**From:** [Eberle, Dan](#)  
**To:** [Jeff Watson](#)  
**Subject:** FW: BL-10-00034 KCFD 7  
**Date:** Tuesday, September 21, 2010 7:41:39 AM

We have no comments on this BLA if the following understanding is correct:

Boundary Line Adjustment

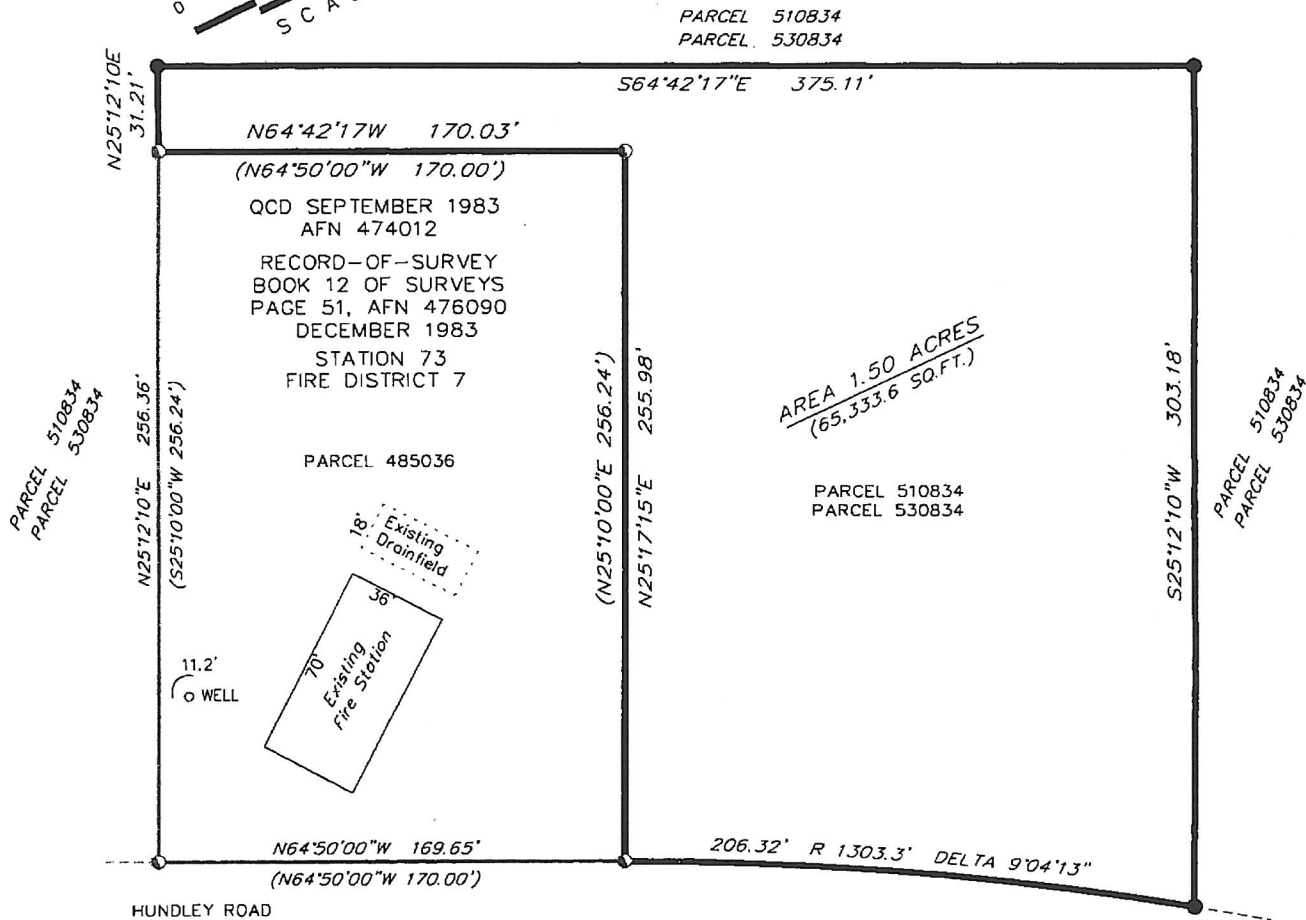
- 1.) There are no new parcels created
- 2.) The Fire Depts. Single parcel will expand from 1 acre to 2.5 acres
- 3.) The Fire Dept. will relocate its approach further to the east upon construction of the new facility.

We will want to see the site plan when the Fire Dept. decides to go ahead with the construction of the new fire station.
